**Consultation Response from KC,
Strategic Housing**

2024/90255 Land Off, Burn Road, Birchencliffe, Huddersfield, HD3 3BT

Reserved matters application, including the considerations of appearance, landscape, layout, and scale for the erection of 22 dwellings pursuant to outline permission 2019/94051 (outline application of up to 39 dwellings and associated works), discharge of conditions 27 (Arboriculture Assessment), 28 (Ecological Assessment), 29 (Public Right of Way)

Responding Ref: SH/24/90255

House Type D1 - Plans and Elevations

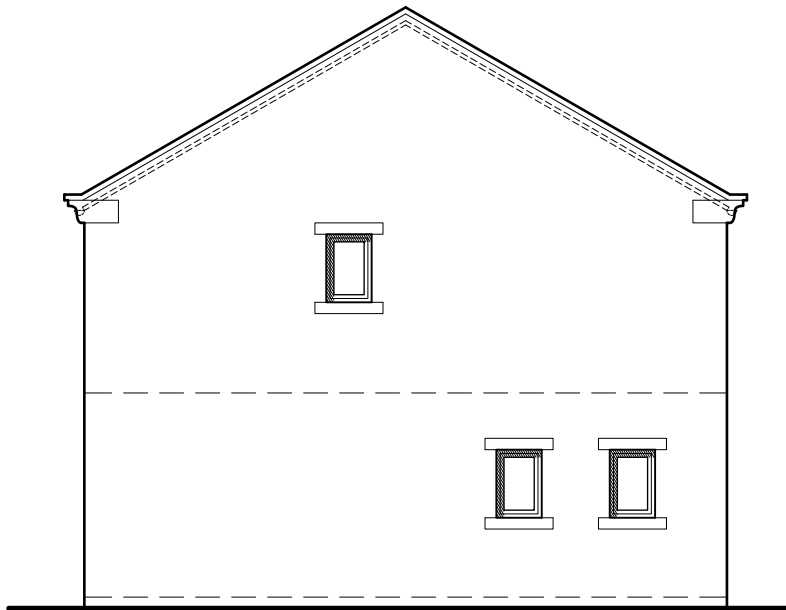
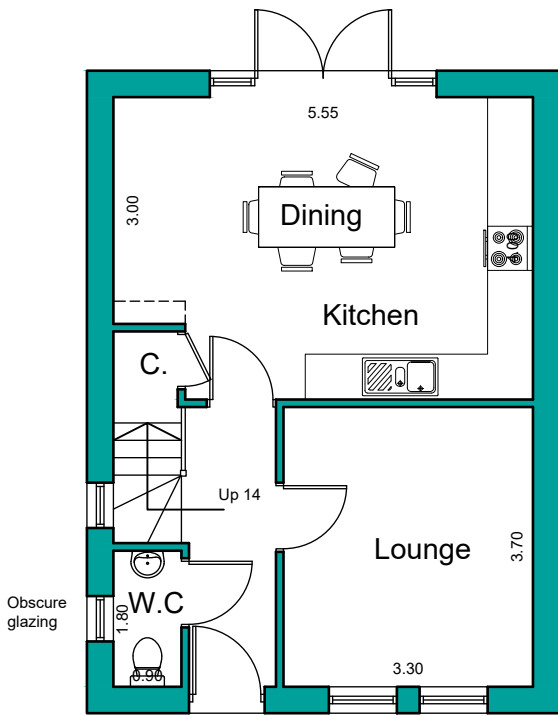
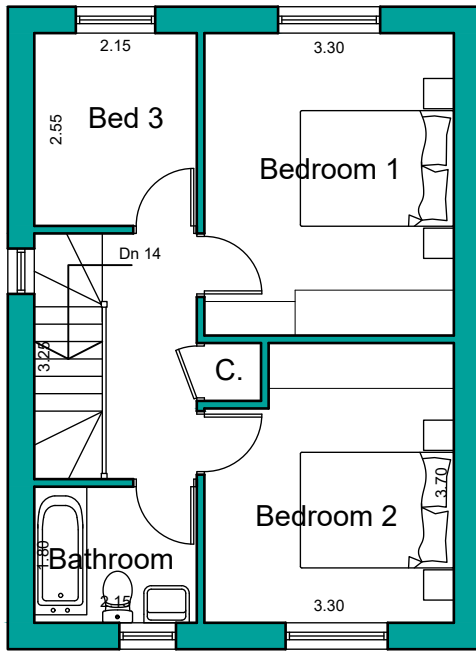
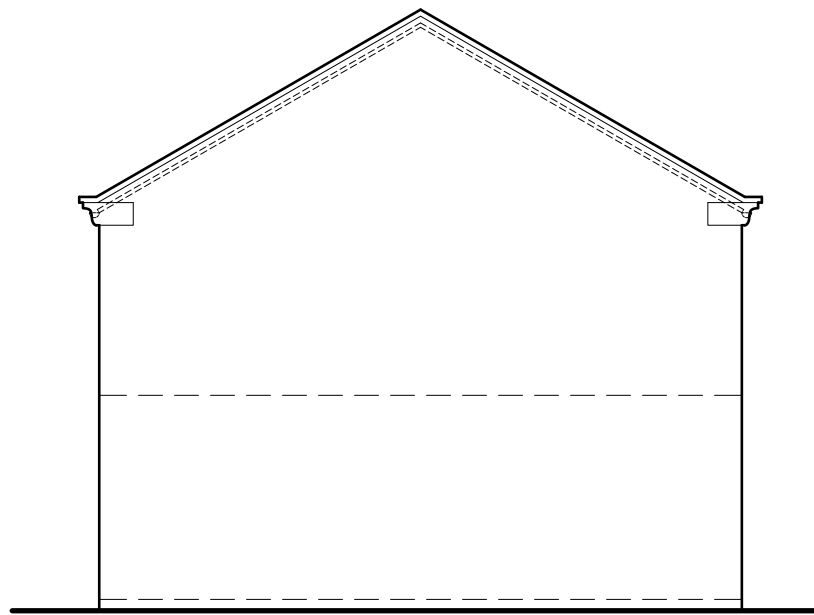
The proposed layout shows that the affordable homes are not distributed evenly throughout the development, as all of the affordable units are the same house type, are the only House Type D dwellings on the development and are clustered together in the middle of the site. This may make them easily distinguishable from the proposed market housing. Therefore, Strategic Housing **does not** support the current proposal.
